Application Reference: 2026/0602

Site Address: 106 Kingsway, Staincross, Barnsley, S75 6EU

Introduction: This application seeks full planning permission for an increase in roof height to create loft conversion for habitable area, removal of detached garage and replace with 2 storey side extension, change to front entrance steps and new render finish to rear of dwelling

Proposed Elevations

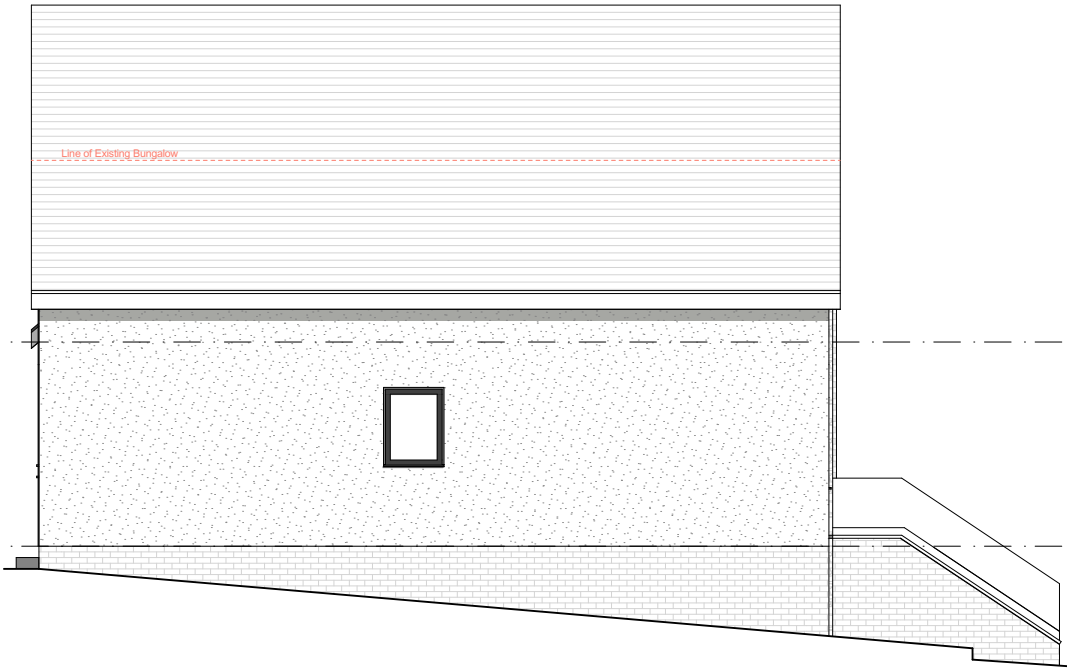
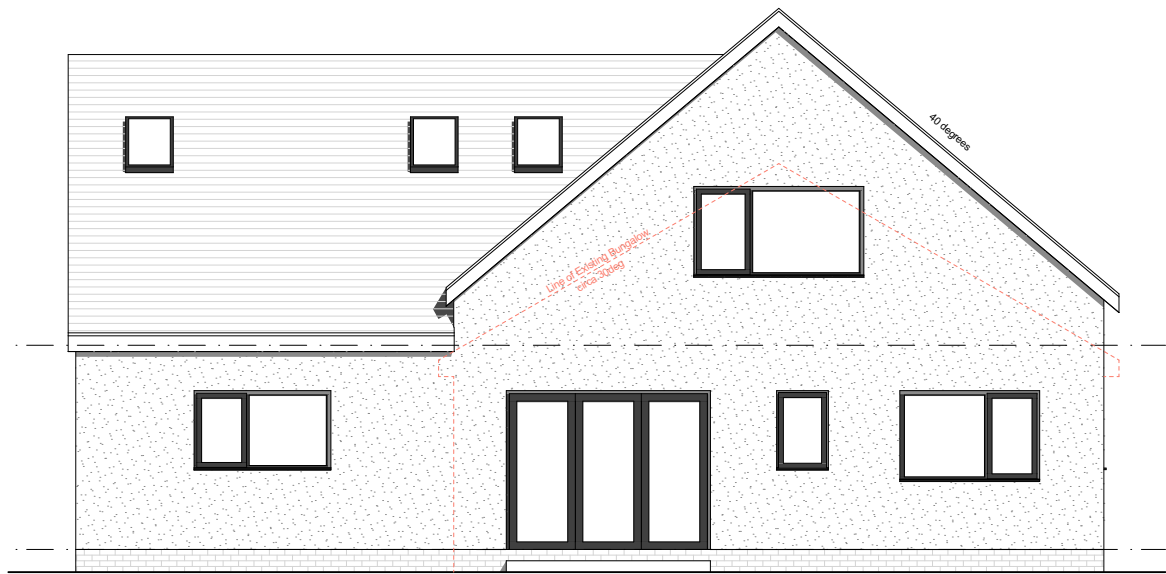
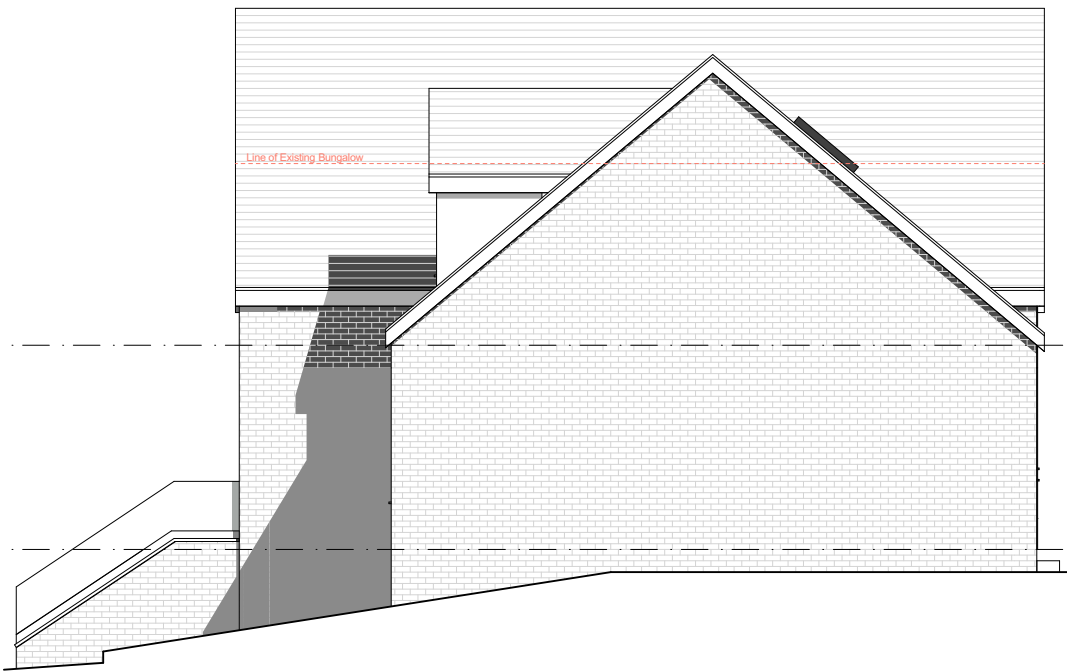
The scale of the original dwelling would be impacted by both the increase in roof height of the original dwelling, increasing from approximately 6.3m to 8.35m, and the proposed side extension with its side projection of 5m and approximate side gable roof height of approximately 7.75m. The external steps would have less of an impact on the scale of the dwelling.

Specifically in relation to the side extension, with the dwelling having an original width of approximately 8.6m, and local SDP House extensions and Other Domestic Extensions allowing for side extensions to be up to two thirds the width of the original dwellinghouse, the 5m side projection of the extension would comfortably meet this criterion. Whilst both the eaves and roof height of the extension exceed that of the original dwelling, measured in the same location, both remain lower and therefore subordinate to eaves and ridge heights of the heightened dwelling. Such subordination is significantly noted in the 0.6m height differential between the heightened original roof and proposed extension.

Progressing to the design of the proposal, again it is quite a significant change from the original design of the bungalow. The proposal introduces a dormer or 1.5 story aspect to the dwelling, with a further sideways extension expanding the dwellings width. There is also the introducing an additional roof, although with a complementary styled side gable roof, seamlessly attaching to the heightened original gable roof.

Further introduced are a front dormer window in the roof of the extension which would be constructed of a composite material in dark grey to match the colour of the proposed new roof. Rooflights are also proposed for the front elevation roof of the existing dwelling. Along with the dormer style of bungalow, the proposed features are found within the broader street scene, although not on the adjacent, almost identical bungalow. Of no 106 As with the scale, the larger set of external steps would have little impact on design, but the expanded rendering of the dwelling would.

Whilst render is present on the side elevation and within the street scene, the almost full rendering of the dwelling would have an impact on its design and character. This impact is softened through a proposed cream/beige colour render (suggested as the proposed colour by the applicant) to match the existing brickwork, and through the retention of a section of original stone section of the dwelling, the dwelling would maintain some of its original character without having a significant impact on the broader street scene.

Proposed Plans

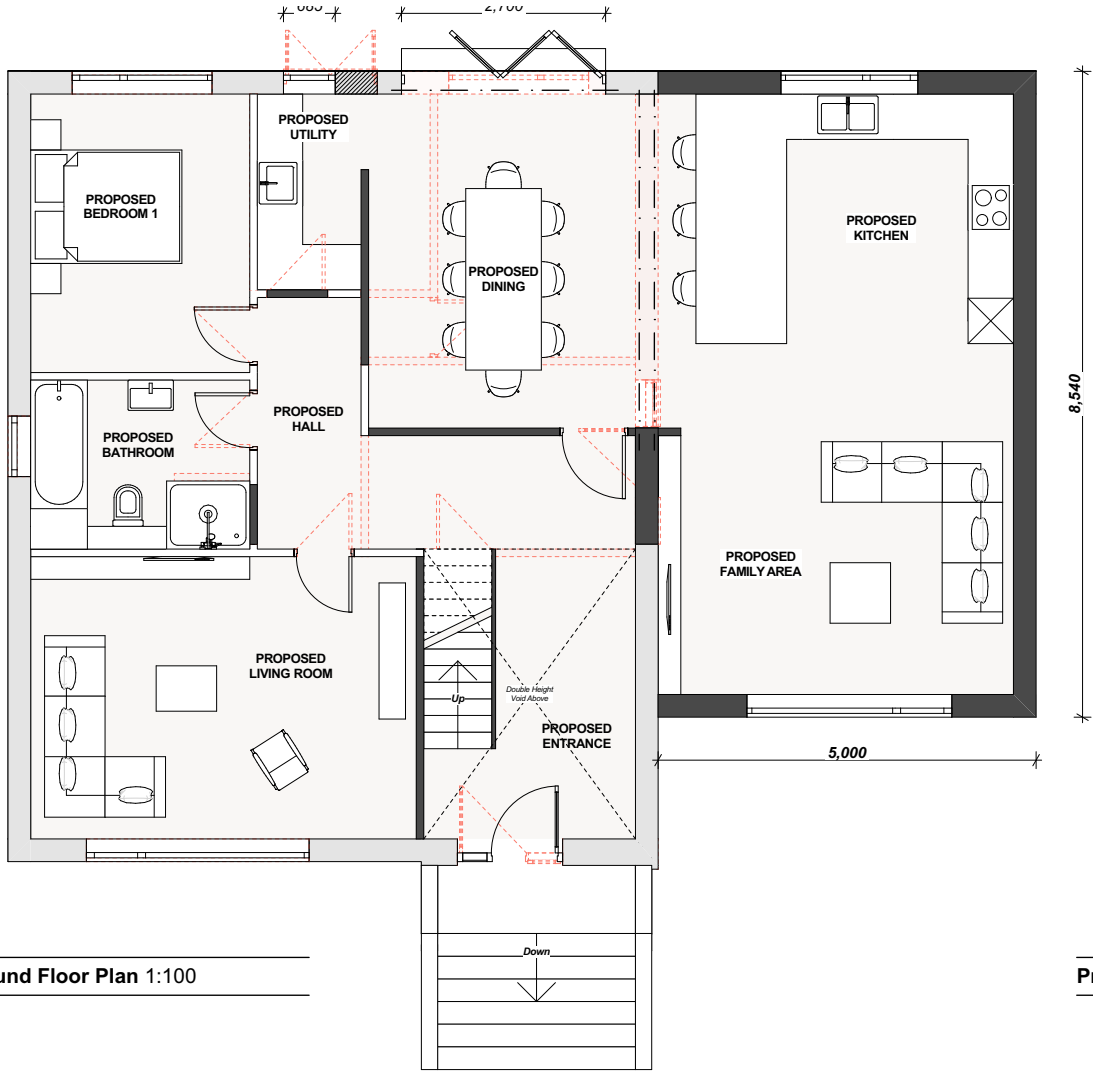
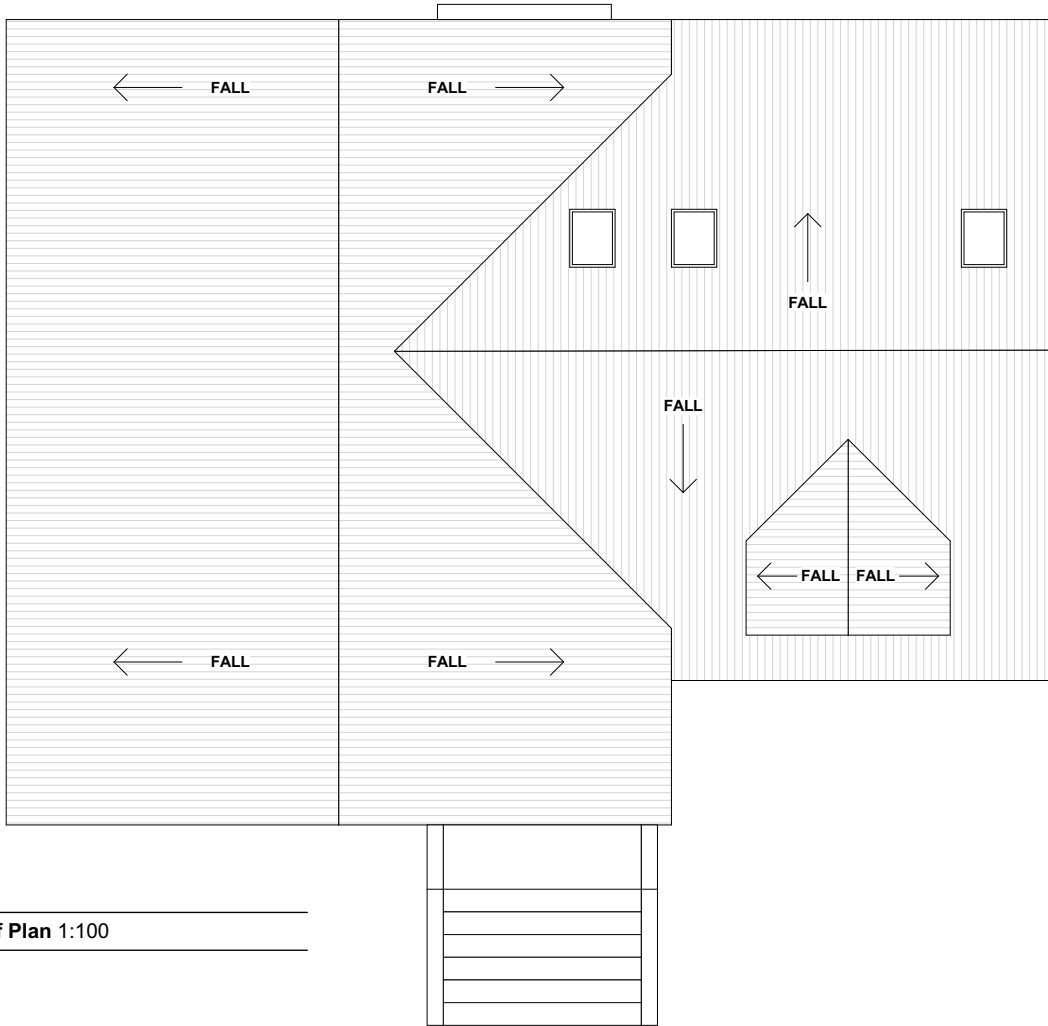
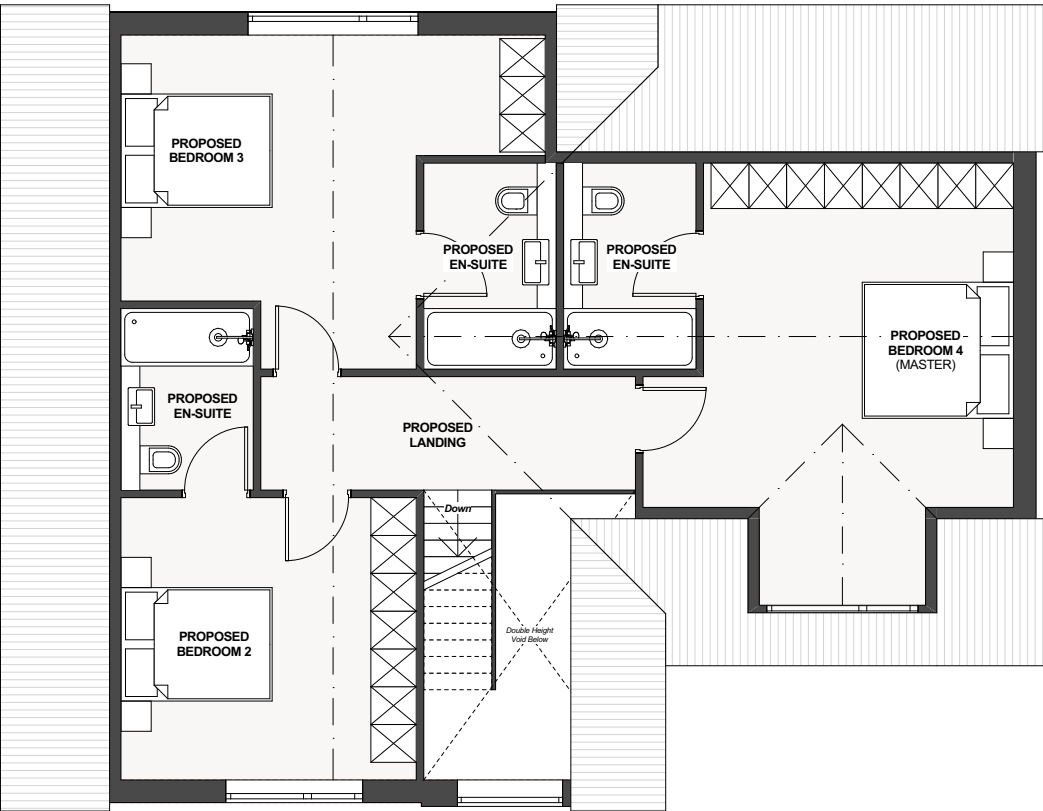
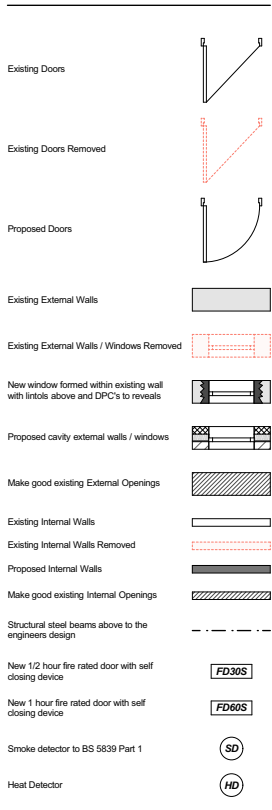
In terms of footprint, the dwelling, including the external steps, it would increase the dwelling's footprint from approximately 95.5 sqm to 141 sqm. Because of the creation of habitable space within the roof, the approximate habitable floor space of the whole proposed dwelling, excluding external steps would increase from approximately 90 sqm to 221 sqm. Whilst the increase in habitable space has more than doubled, the approximate footprint of the dwelling has not increased as significantly. Part of the 45.5 sqm increase in footprint would be constructed within the footprint of the former 15 sqm garage, which has recently been removed. For comparison, the curtilage of the dwelling, excluding the original bungalow is around 493 sqm.
